Re: Responses to the following comments, EA Number EA1881, File Number AL2014:

- **Ellicott Sand and Gravel, Traffic Report (Combined):**

**Ellicott Sand and Gravel
Traffic Impact Analysis
PCD File No. AL2014
(LSC #194980)
March 31, 2021**

Figure 8
**Site-Generated
Traffic Volumes**
Ellicott Sand + Gravel (LSC# 194980)

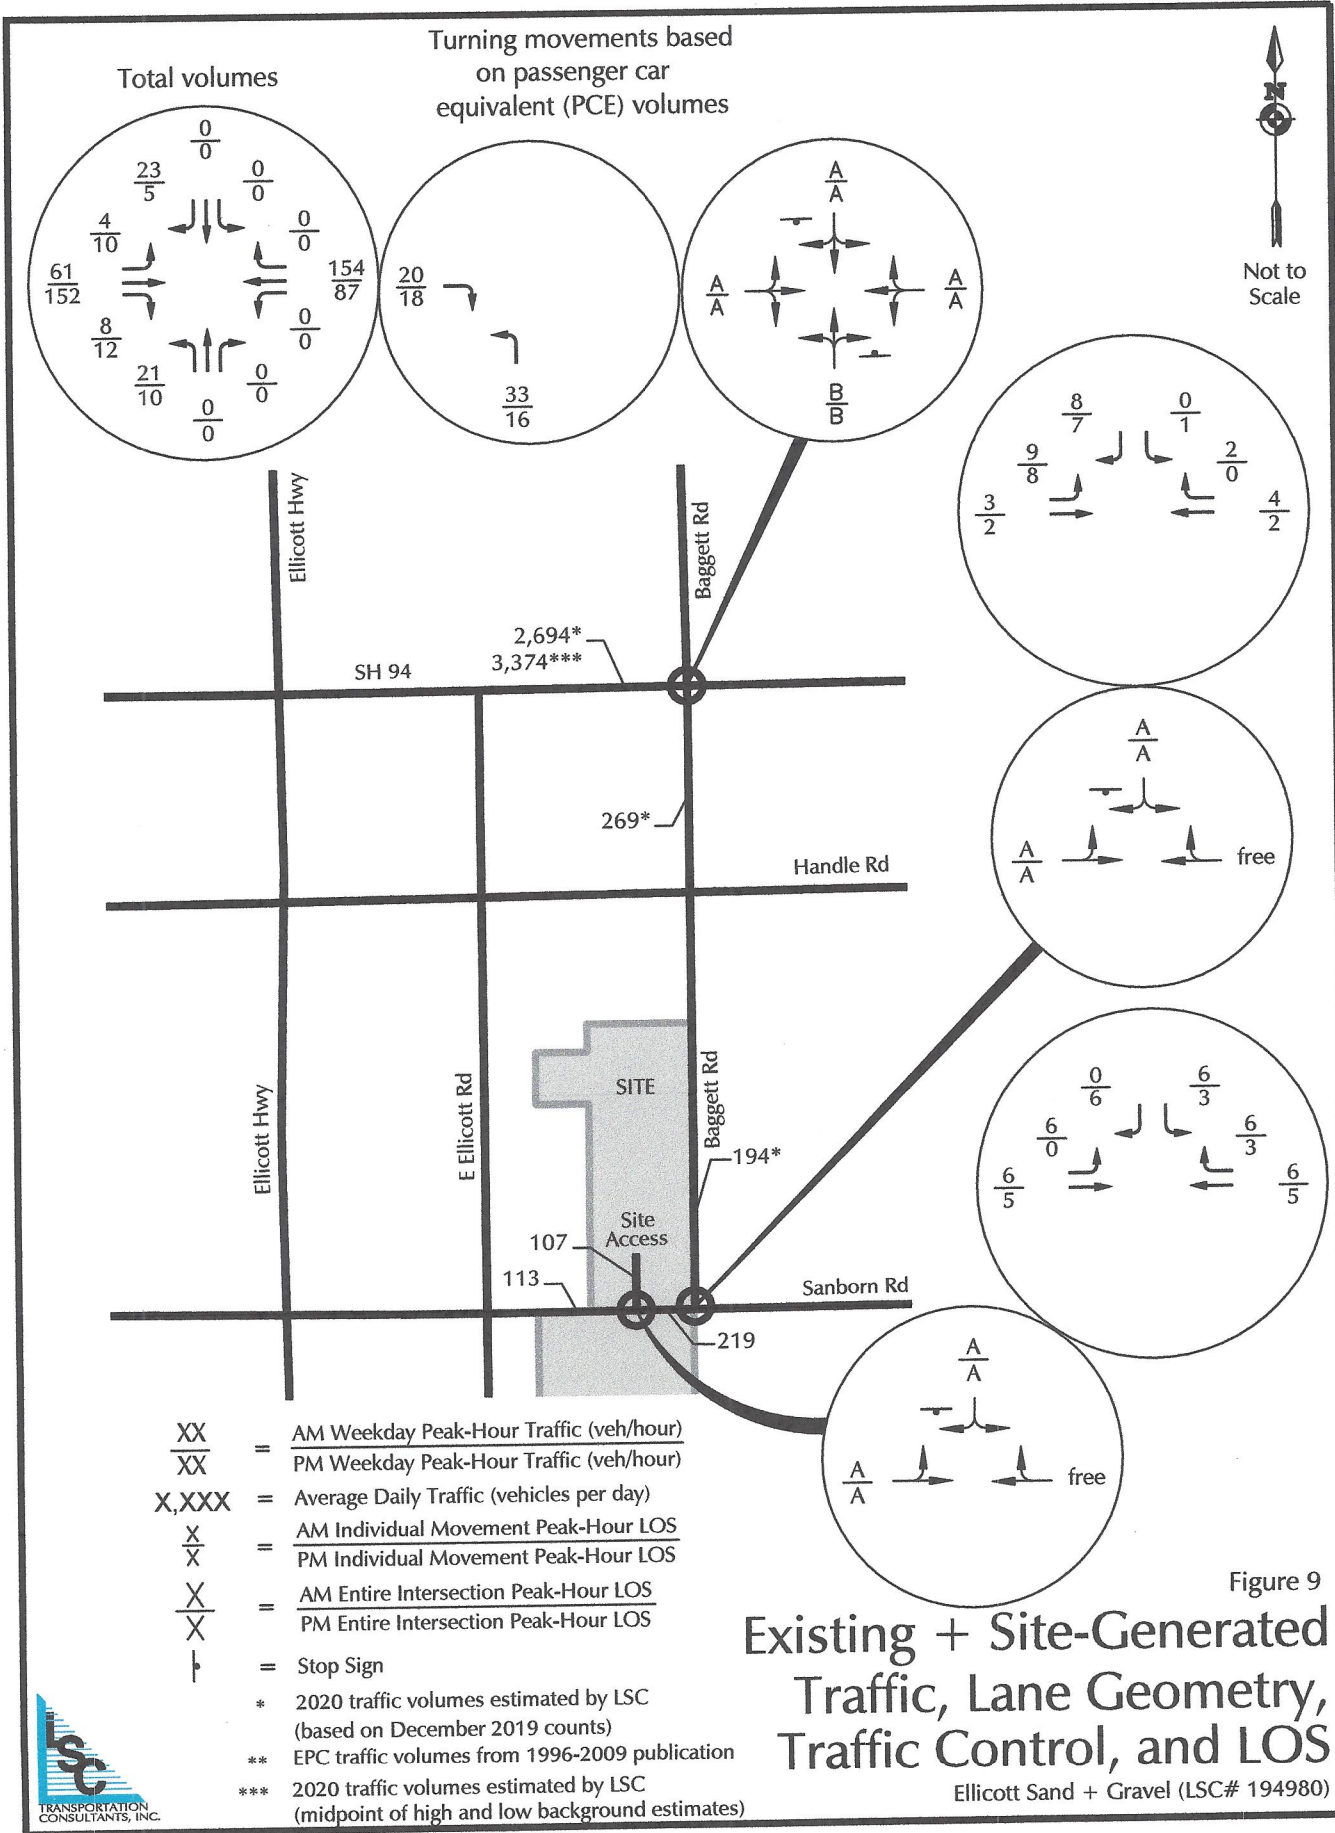
figure 12 shows the 2040 background + site
long term traffic. Please revise.

Figure 10 shows the sum of the 2040 Background traffic volumes (from Figure 6) and long-term site-generated peak-hour and daily traffic volumes (shown in Figure 8). These volumes represent the potential long-term total traffic.

figure 9

Figure 11
**2040 Background Traffic,
 Lane Geometry, Traffic
 Control, and LOS**
 Ellicott Sand + Gravel (LSC# 194980)

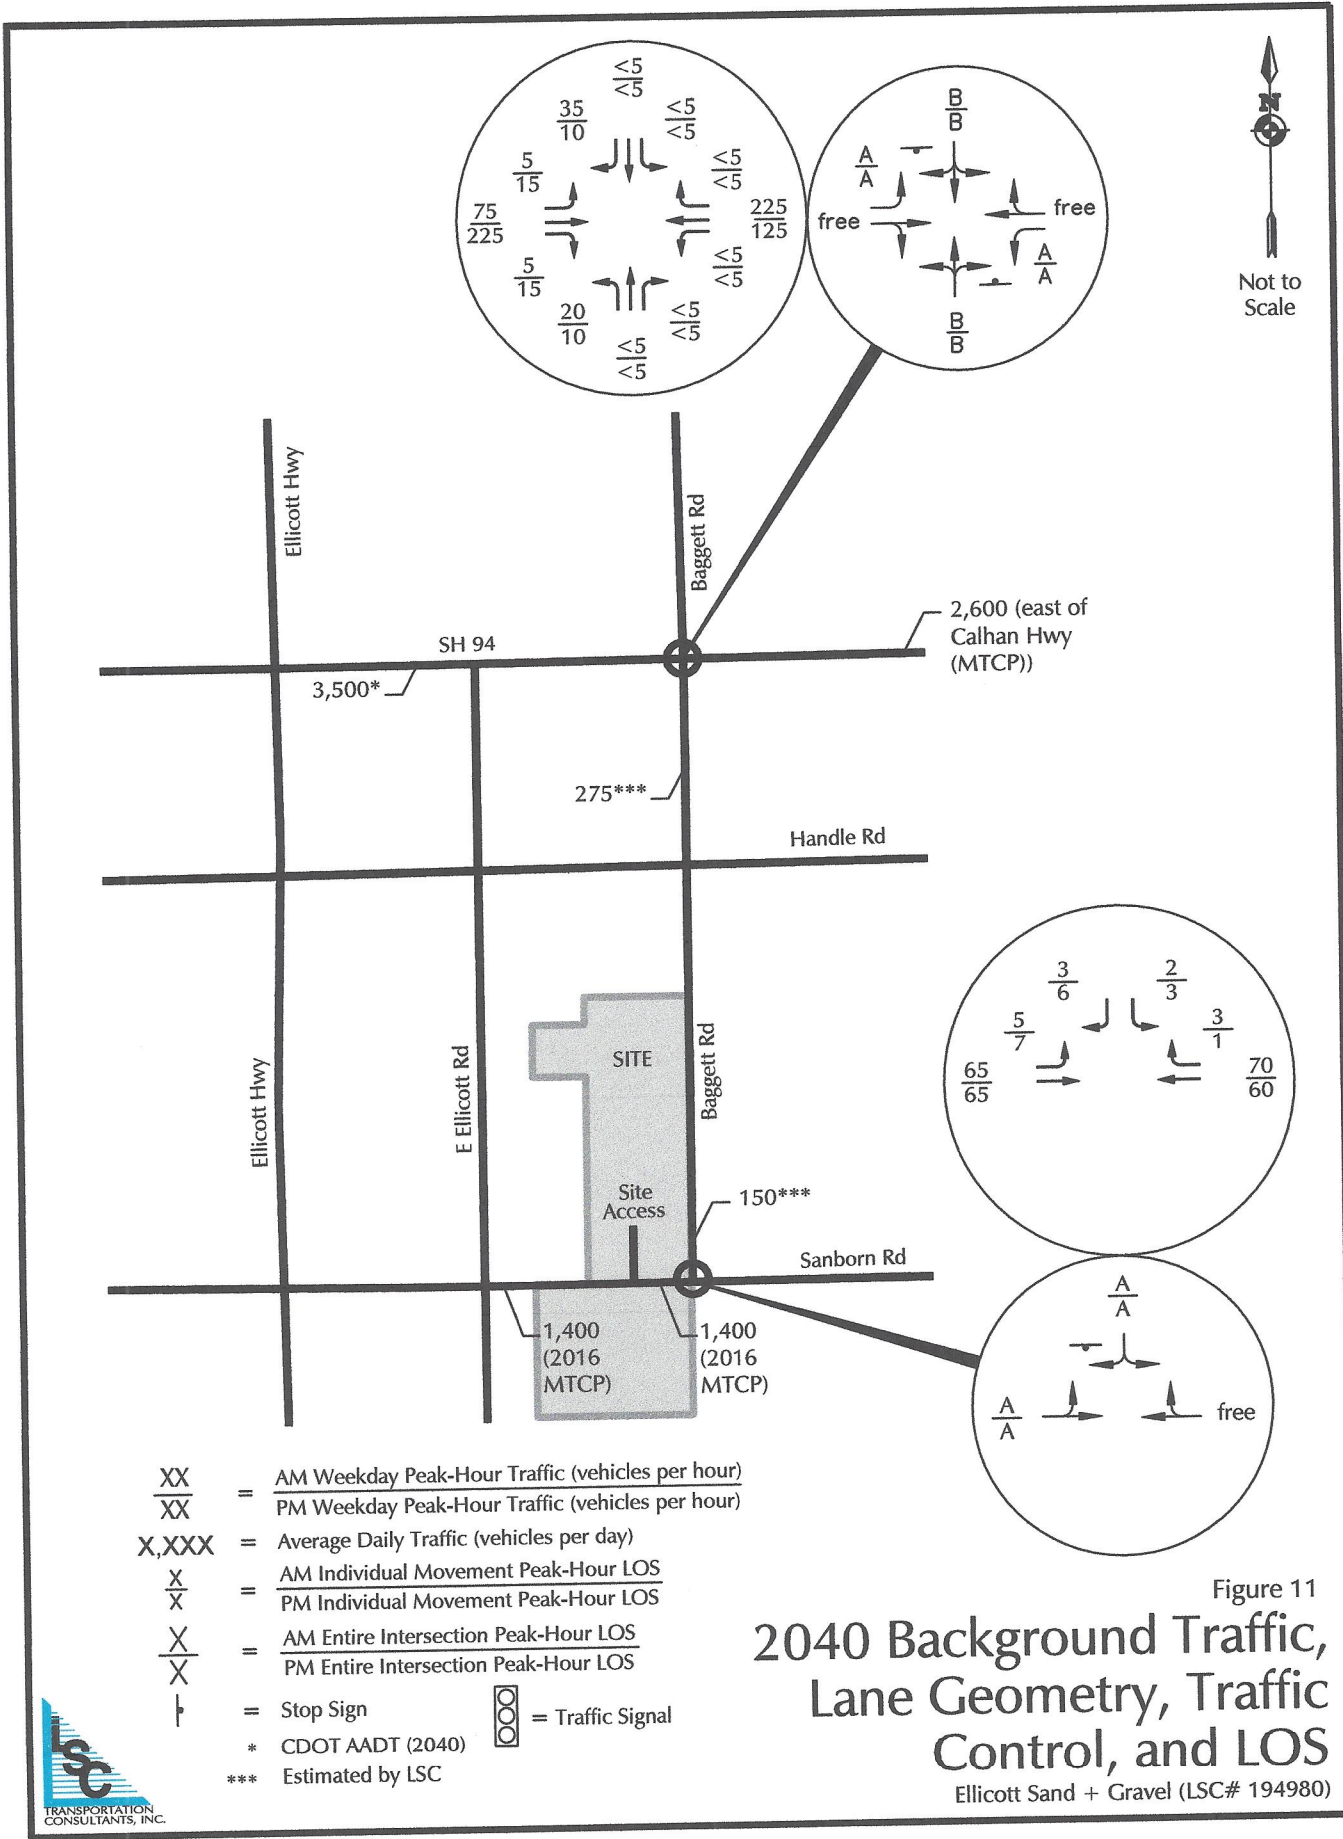
figure 11
